**Consultation Response from KC,
Trees**
2025/91961 adj, 315, Wakefield Road, Lepton, Huddersfield, HD8 0LX
Demolition of existing buildings and erection of detached dwelling and associated works
Date Responded: 26/09/2025
Responding Officer: Irving
Responding Ref: KB2/50

AS PROPOSED_ SITE PLAN

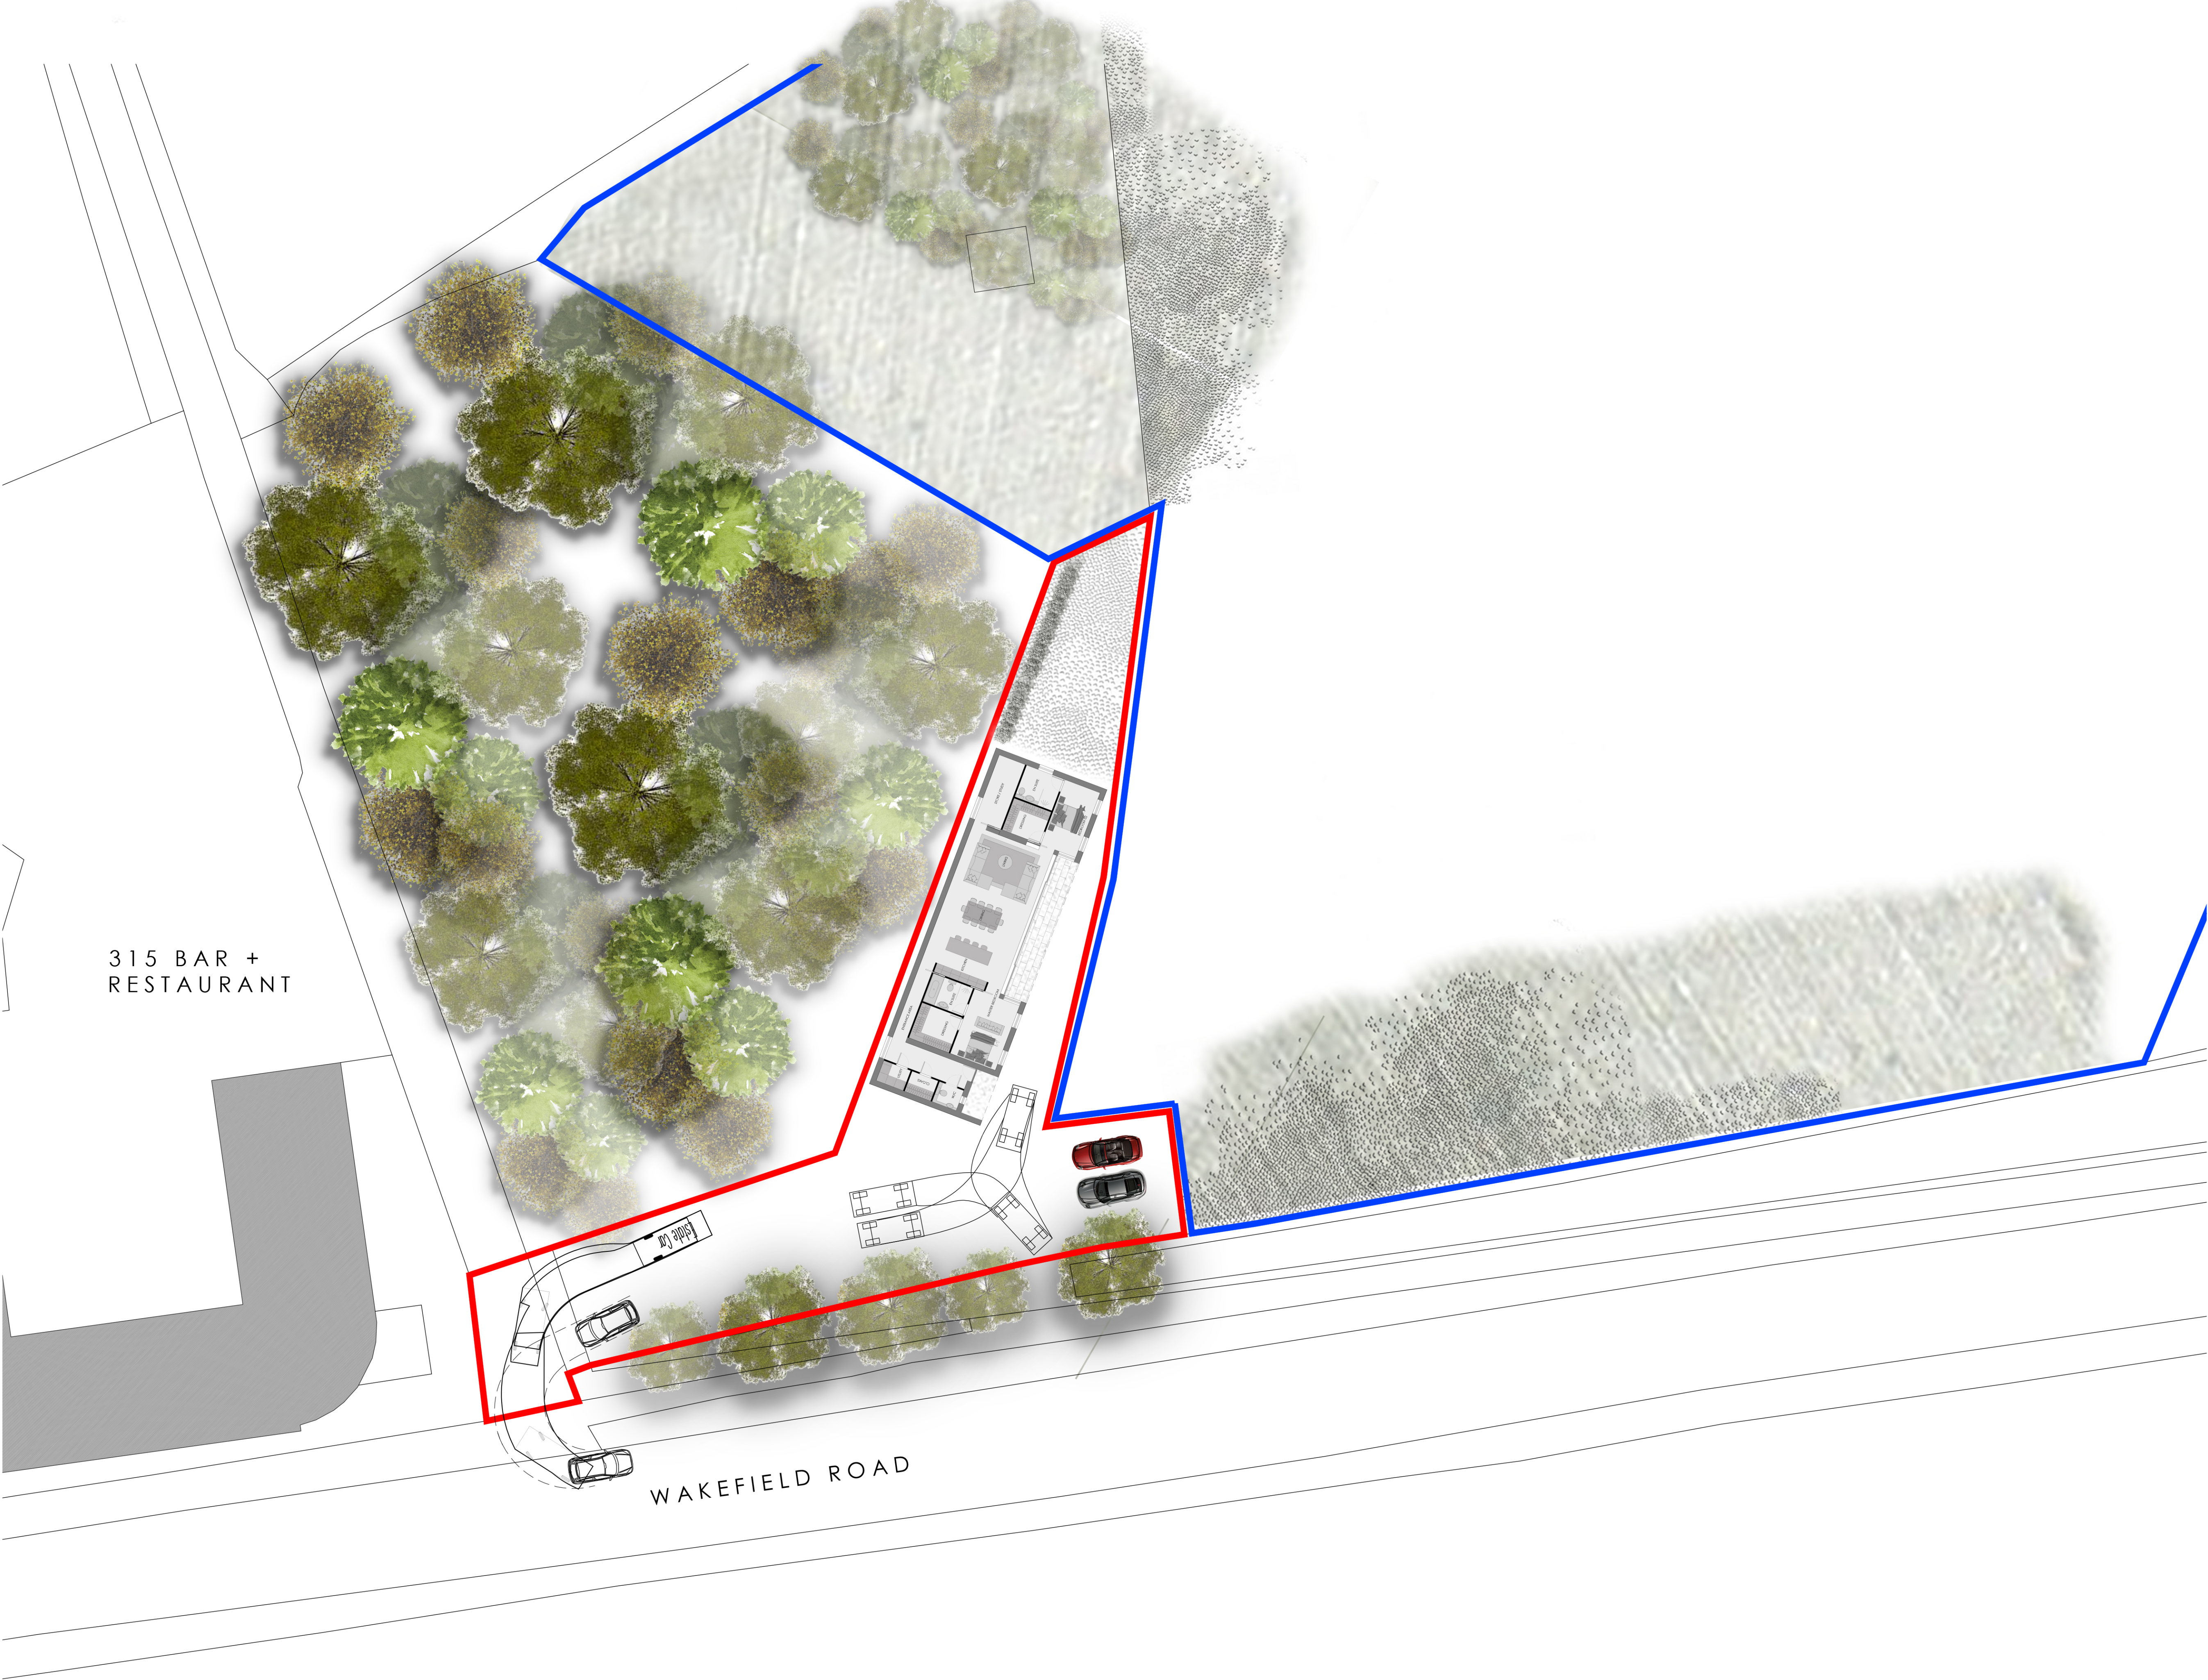
I raised objections in my consultation dated 8th of August 2025. The proposals have not been amended to reduce the significant impacts the development would have to valuable category A trees within a protected woodland.

The proposed structure and drainage layout are sited within the RPAs and canopies or protected trees. The degree of the incursions is unacceptable, and conflict with BS5837:2012 recommendations, as discussed previously. The proposals cannot be supported from an arboricultural perspective as they conflict with Local Plan Policies:
